Application No: EP/67/20/PL
Site Address: Land adjacent to 45 The Ridings East Preston BN16 2TW
Description of works: 1 No. detached house & formation of associated new access.

Thank you for your internet representation made on 8th July 2020 which has been recorded as an objection with the comments as follows:

C SECOND FLOOR CORRECTLY ANNOTATED 10.07.20
D GARAGE SIZE AMENDED AND WINDOWS TO NORTH ELEVATION ADJUSTED 01.07.20
A STREET ELEVATION ADDED 07.04.20
REV. DESCRIPTION DATE

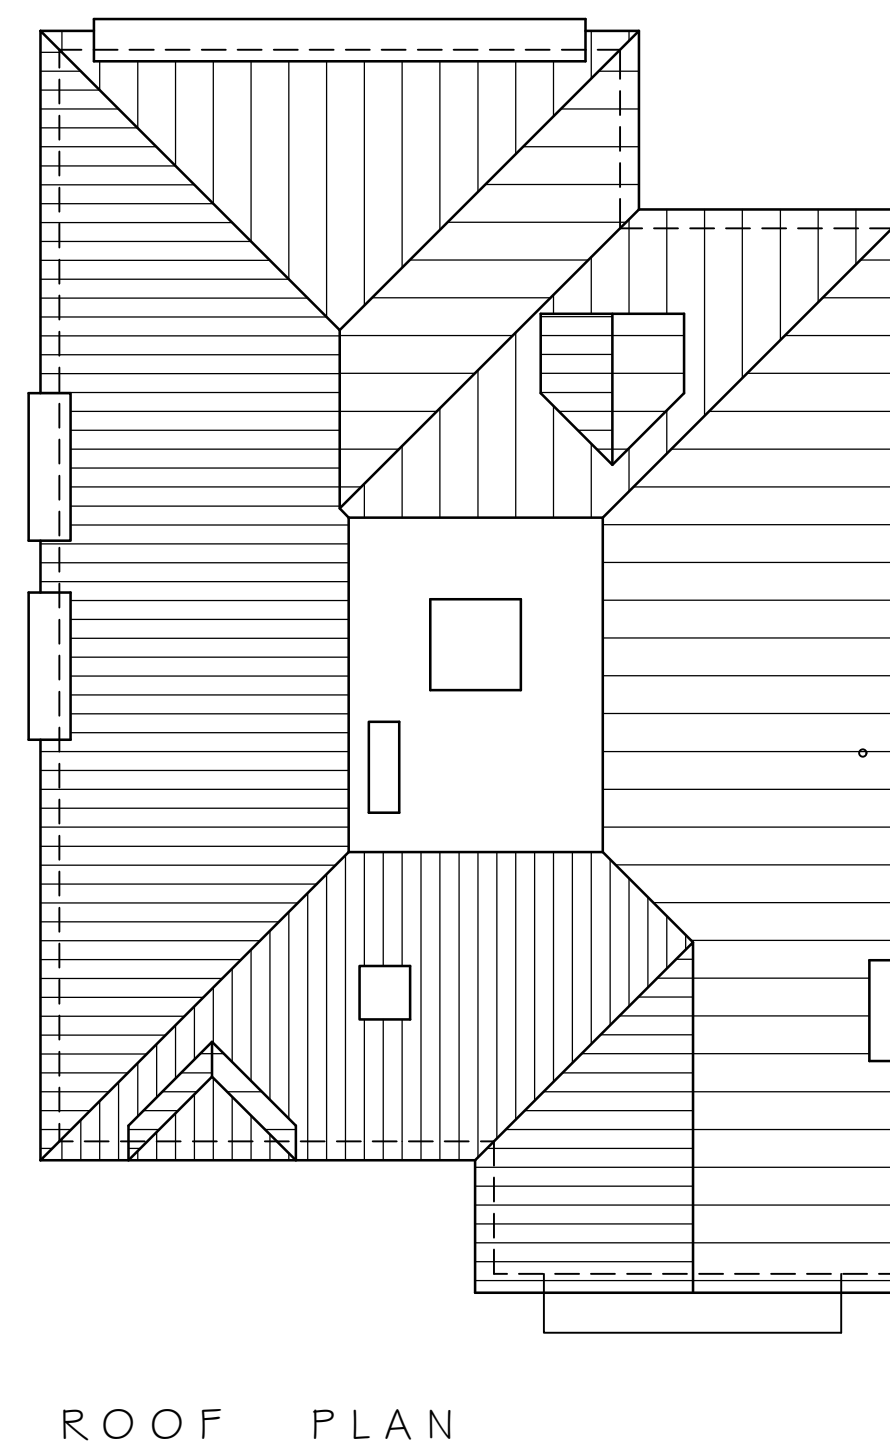
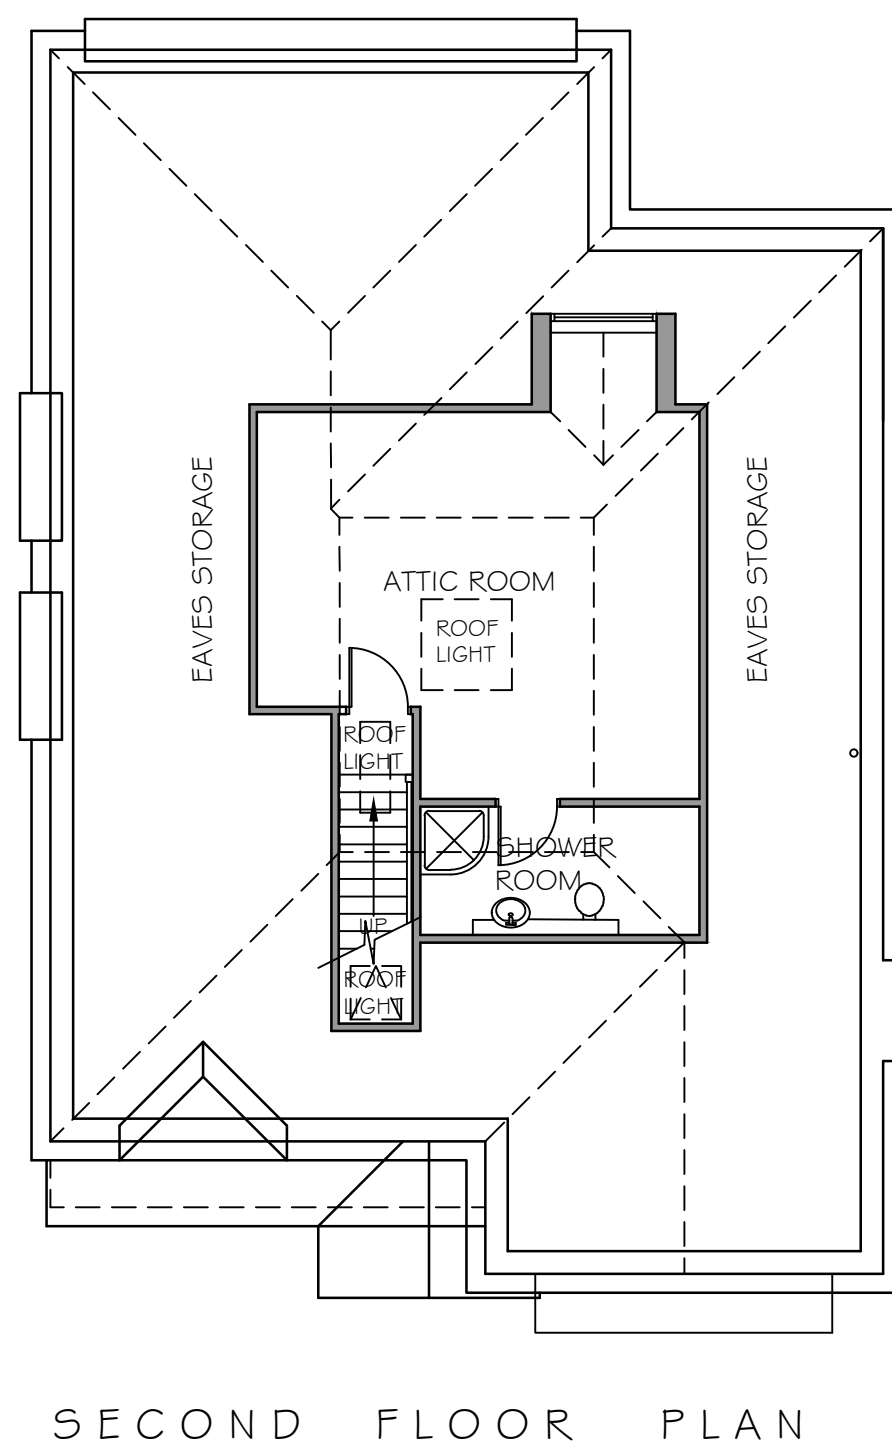
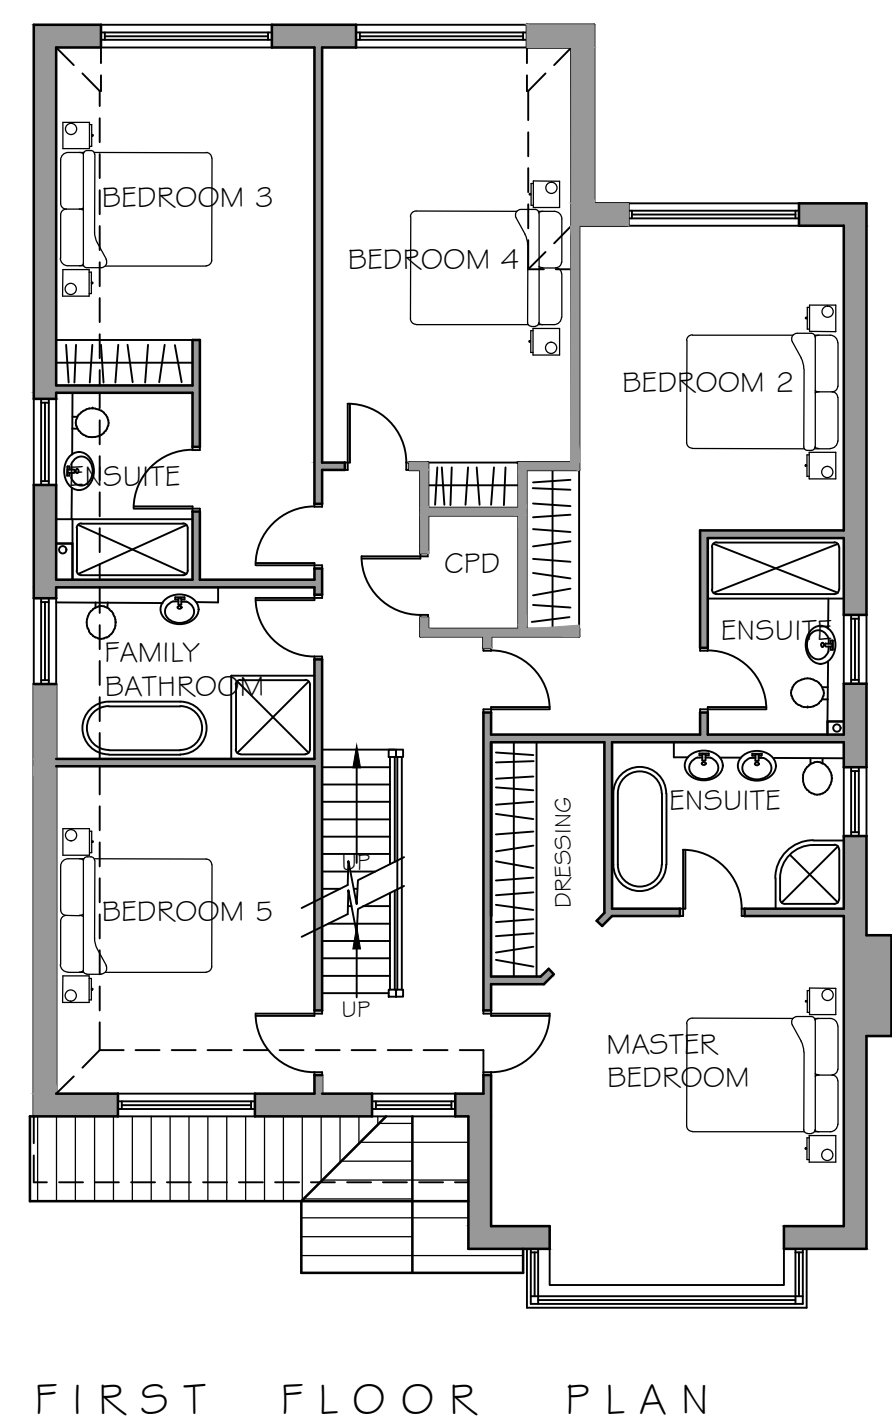
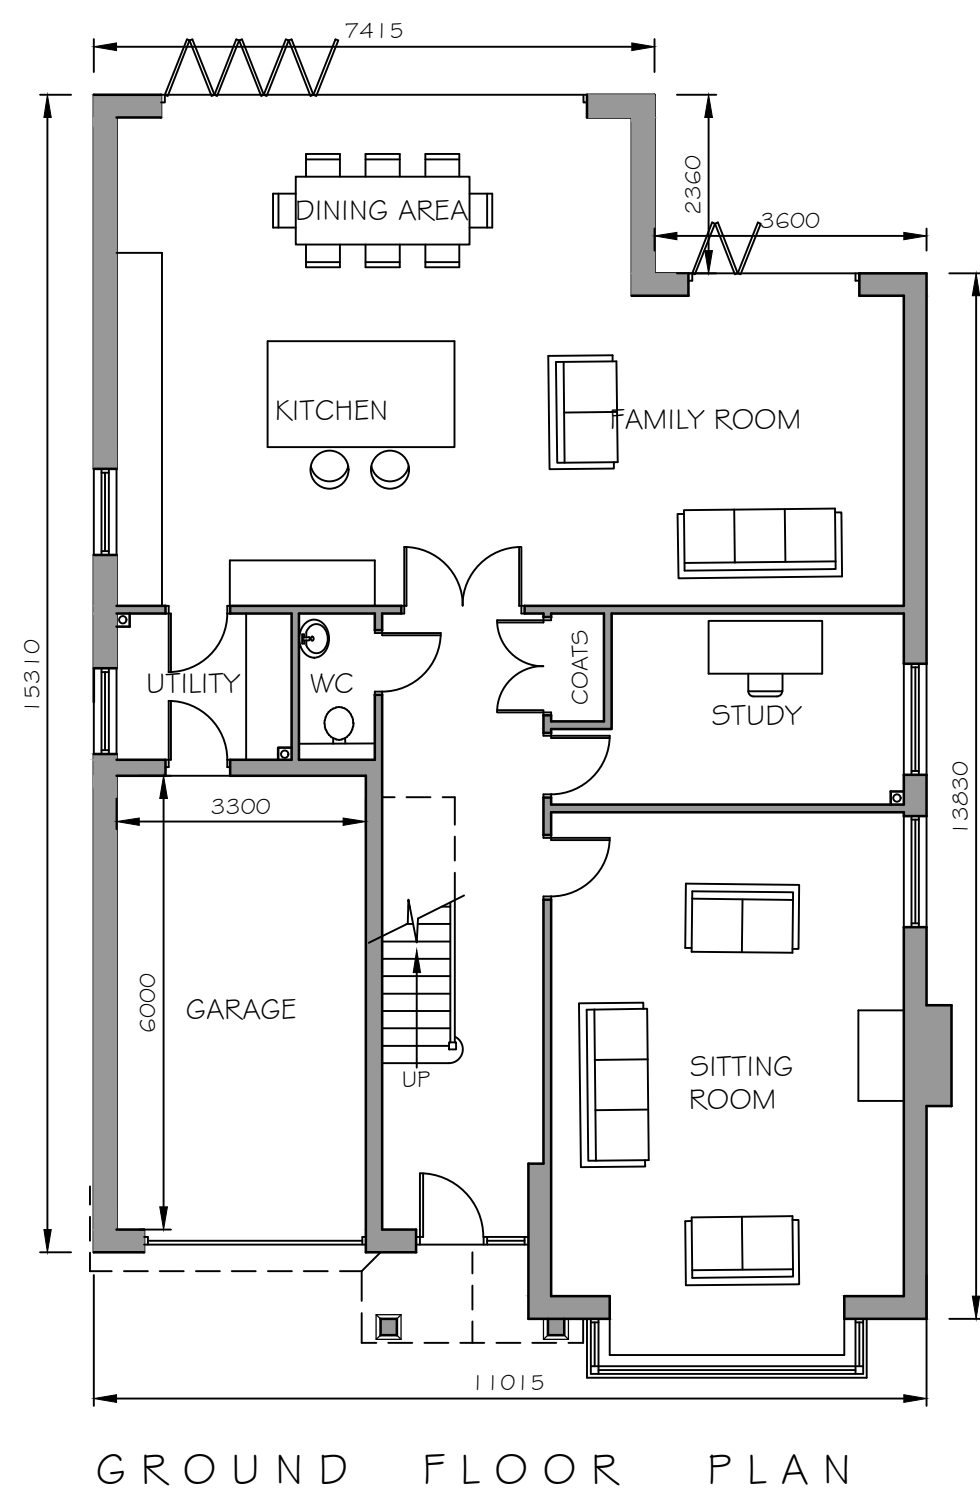
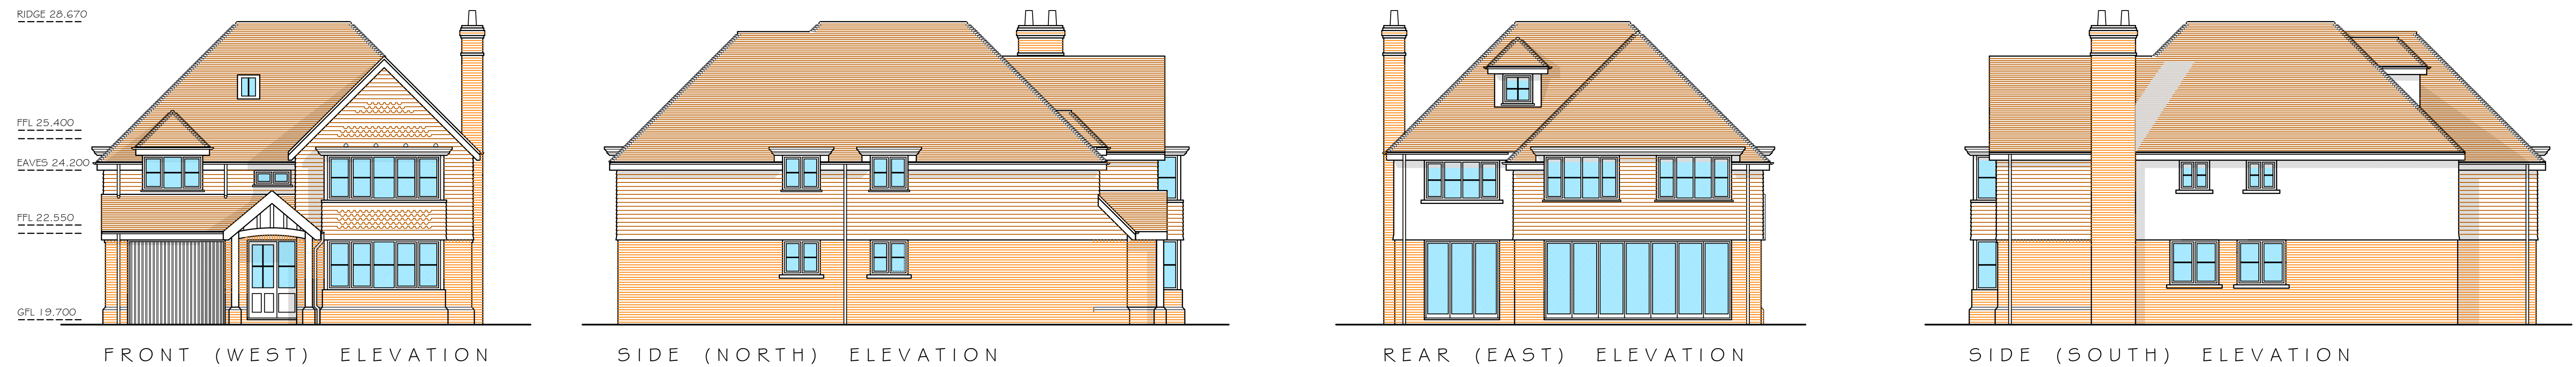
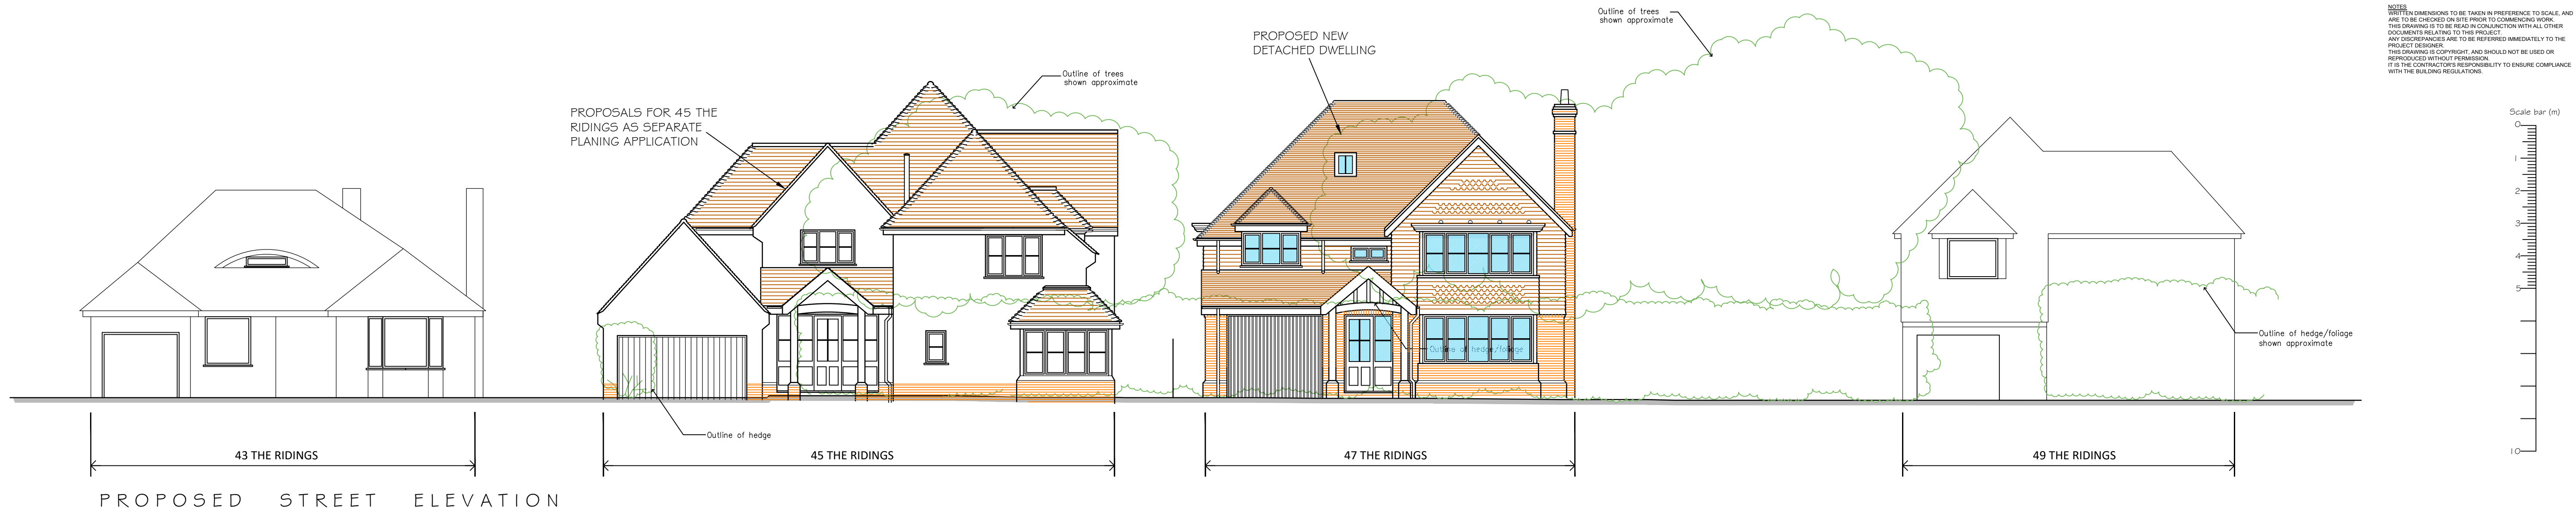
Overall, the property may be a bit big for its location within the plot and streetscene. The committee was also concerned about the exact number of storeys this property will be. Drawing 935/P01B includes two First Floor Plans, which is physically impossible. The committee considered the proposed design would be contrary to Policy 1 of the East Preston Neighbourhood Plan, paragraph 4.14 of which states, New or altered buildings that exceed two stories in height will rarely be acceptable. It is clear from the concerns raised by neighbouring properties the roofspace is seen as a separate storey by those most closely affected.
